Applicant: Scenic Land Developments Ltd

Proposal: OUTLINE - The construction of a business park of up to 60,000 sq.m (GEA) of flexible Class B1(a) office / Class B1(b) research & development floorspace; associated vehicle parking, landscaping, highways, infrastructure and earthworks

Ward: Bicester South And Ambrosden

Reason for Referral: Major Development

CLIENT
Illustrative Masterplan

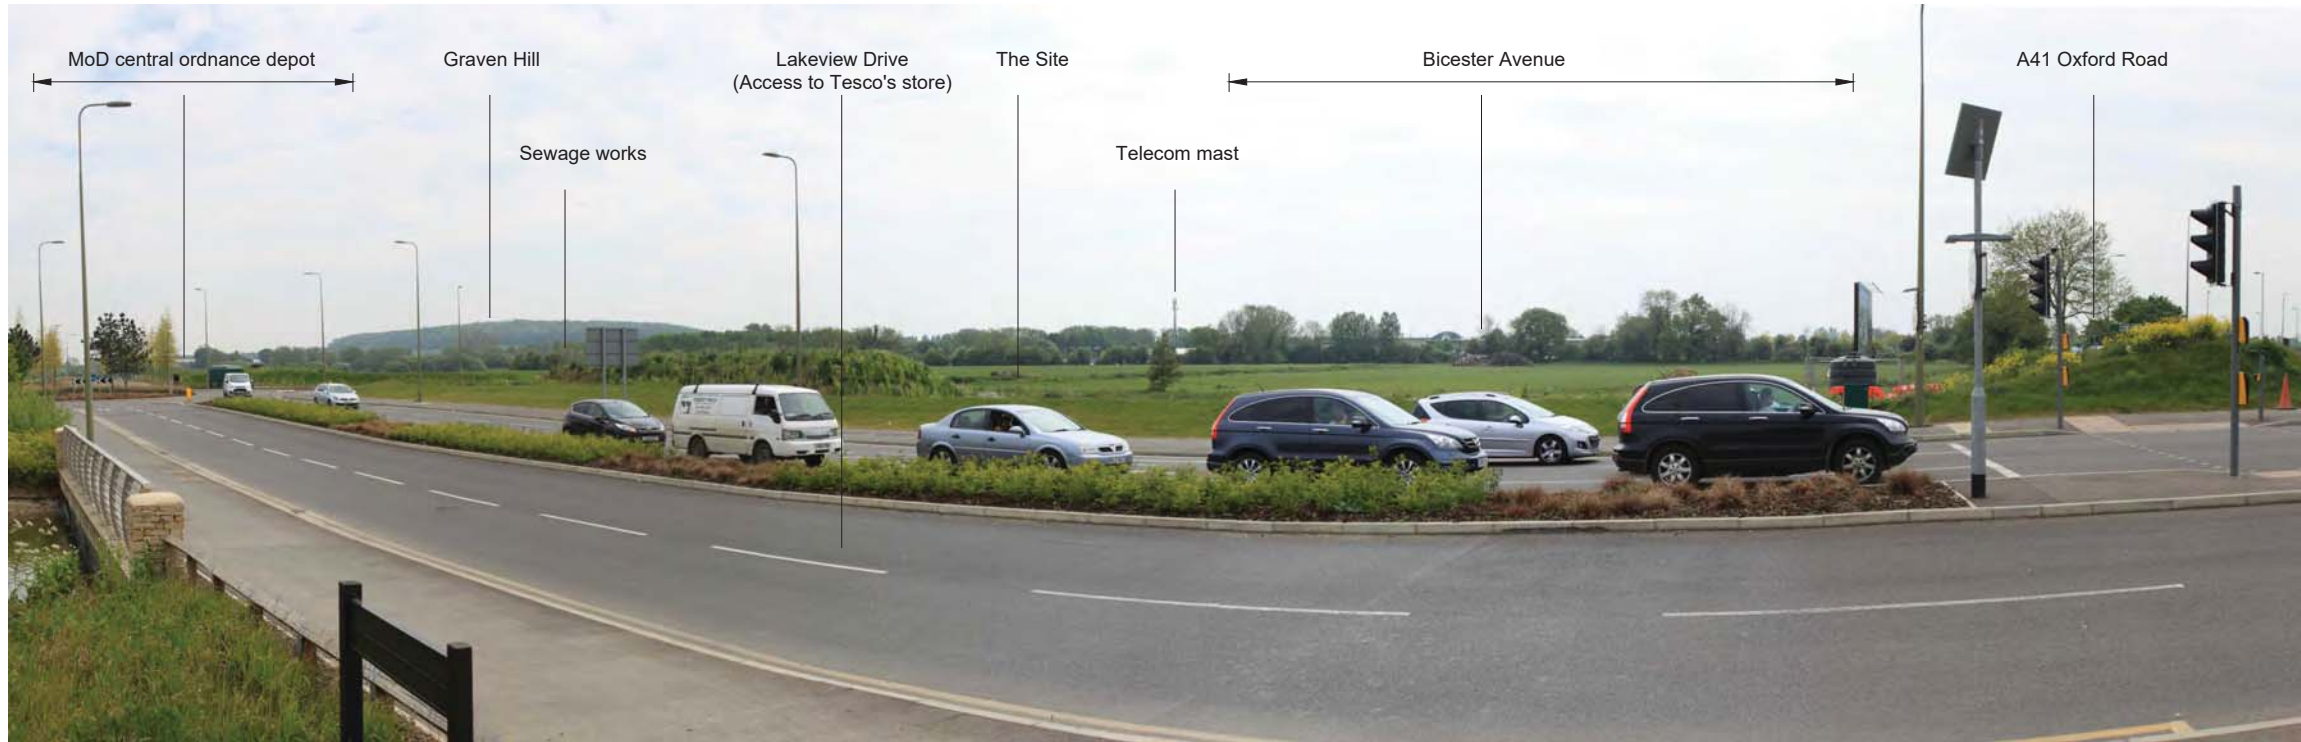
There are no public footpath links between the Bicester Avenue retail park and the proposed development. To be able to walk from the business park to the retail site without recourse to a vehicle is advantageous in terms of health and environmental sustainability etc.

A BS 5837 tree survey is required to ascertain the value of the retained structural vegetation (trees and hedgerows, and the associated root protection zones. This information will inform the design process and influence the layout of the development. In this regard I am concerned about retaining and supporting the site's line of establishing oak trees on the access road to Tesco supermarket; the

hedgerow of the site frontage to the A 41 to be retained and left at its mature height where it exists, and allowed to grow up where it has been cut back (hedgerow reinforcement planting will be required). The existing trees on this boundary should be retained where possible. There is a benefit to road users and site users/visitors (amenity and habitat value) if this hedgerow is retained, protected and enhanced. I am particularly concerned that the Masterplan does not indicate this hedgerow, however the Landscape Strategy in the revised Design and Access Statement states that:

This is reassuring, but evidence of retention of the roadside hedgerow is required in the amended masterplan.
